DRB CASE ACTION LOG (EPC AMENDED SDP-BP)

Project Name: ABQ URBAN CENTER

City of Albuquerque
Planning Department
Inter-Office Memorandum

SUBJECT: Project # 1007015

**SITE PLAN**

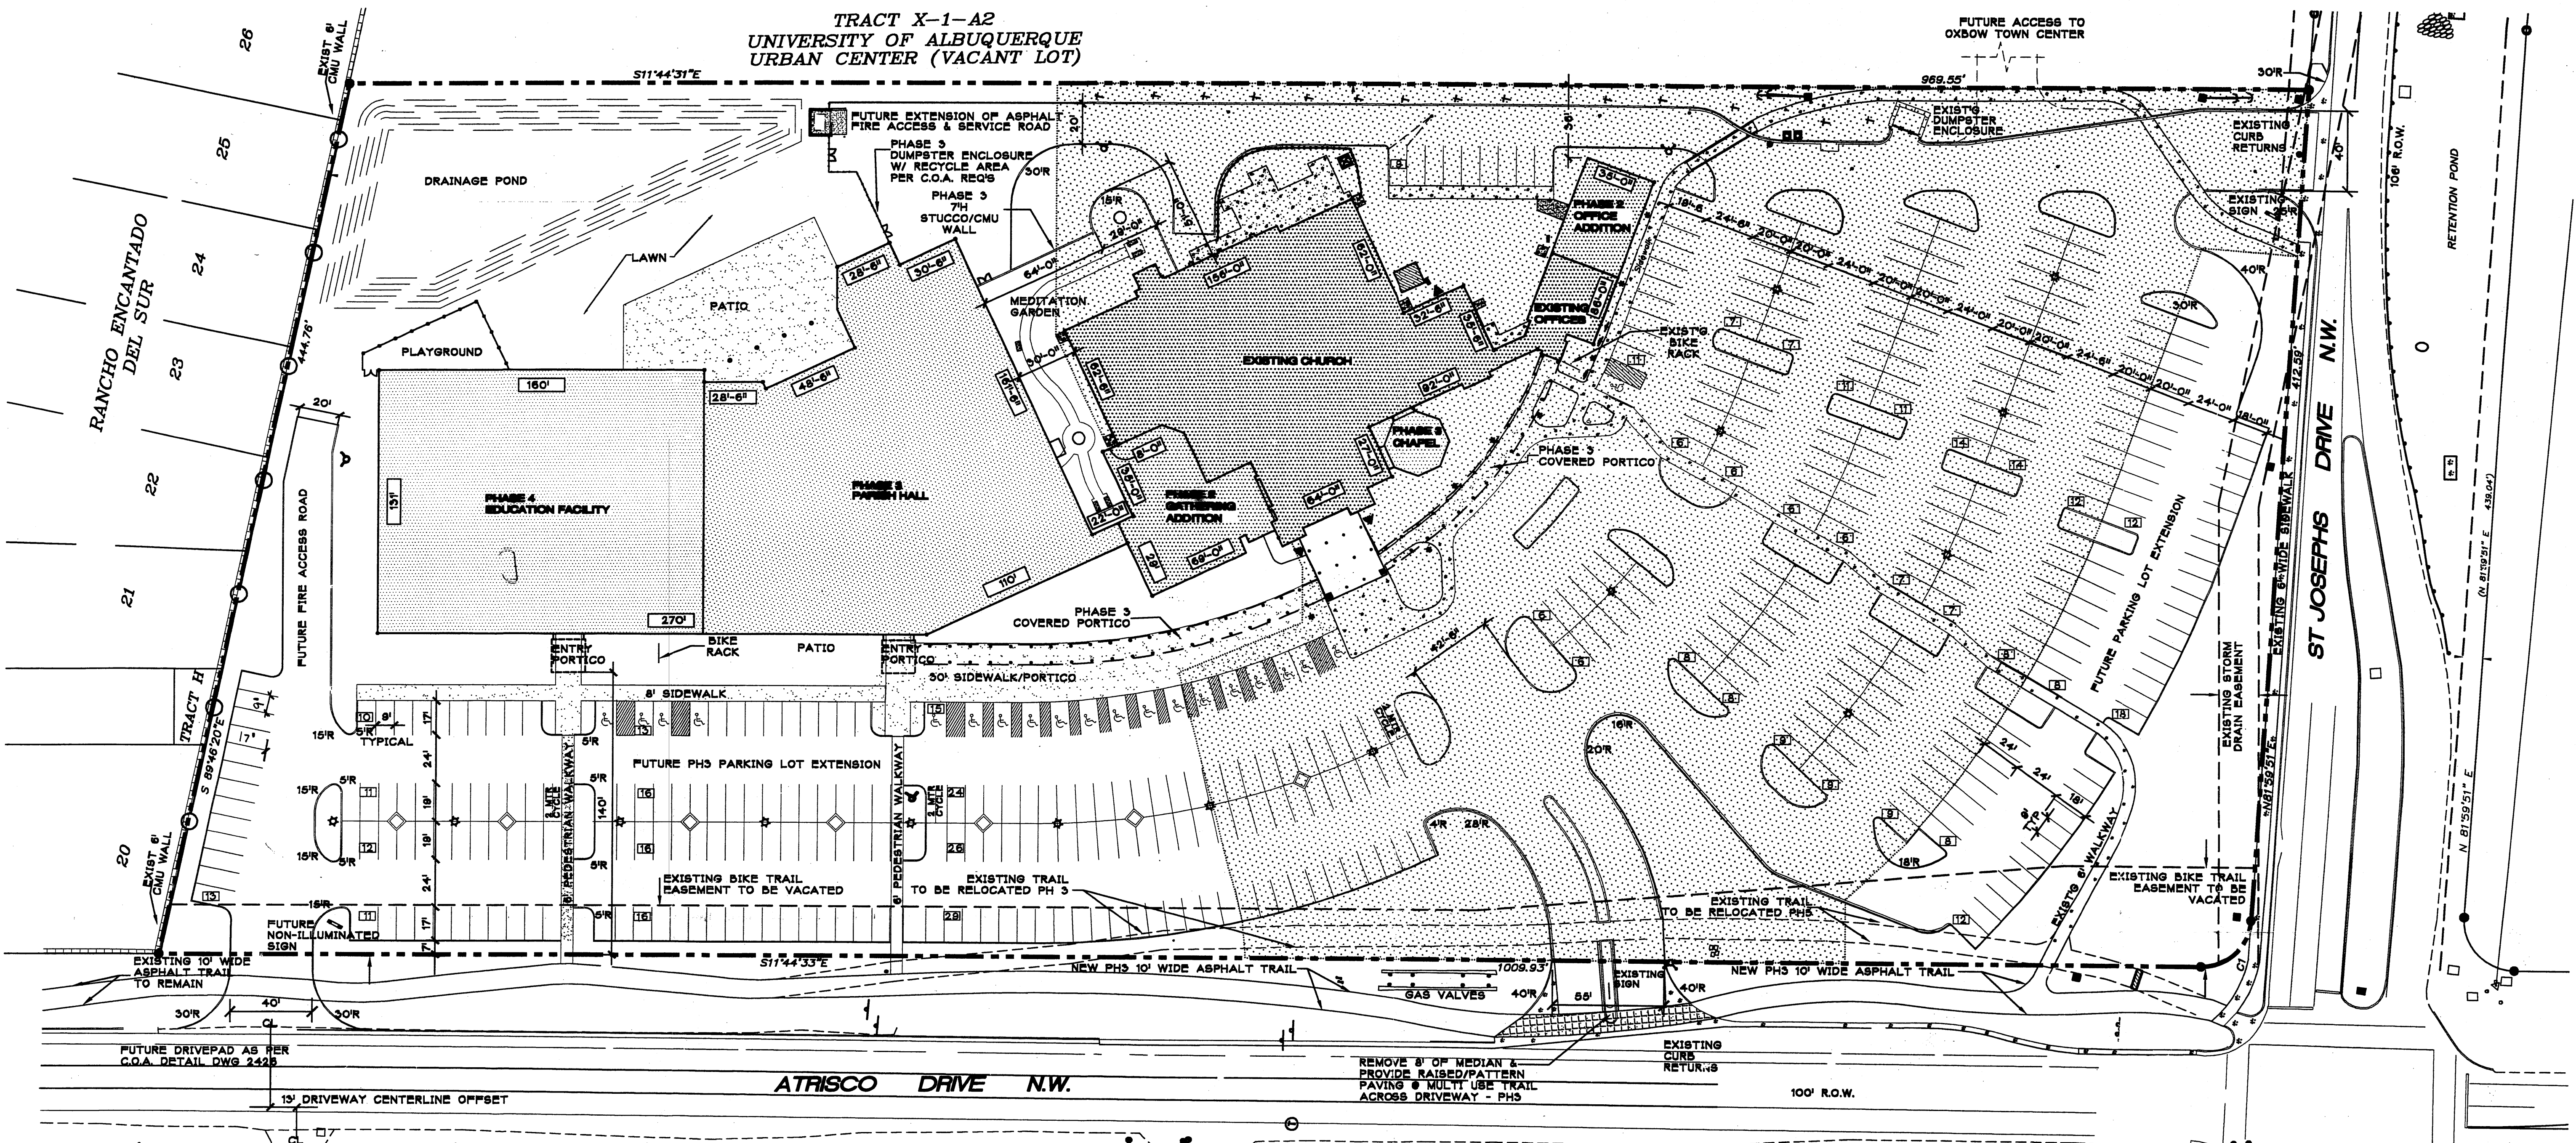
1. Condition 7d calls for the trail along Atrisco to continue across the driveway with raised or pattern paving.
2. Condition 8 calls for the proposed sign to be non-illuminated as a result of being in close proximity to a residential neighborhood. The sign is approximately 75 feet away from a residential neighborhood. Council Bill R-458, Enactment No. 163-1989 in the Coors Corridor Plan states that "light sources shall be shielded so they are not visible from any point on residentially zoned property within 200 feet of the site property line."
3. Condition 10 requests a cross access easement to be entered into between the owners of tract X-1-A-1, the Archdiocese property and Tract X-1-A-2, the Oxbow Town Center Property. There have been ongoing discussions between the two parties and an apparent agreement; however, it has not yet been officially recorded.
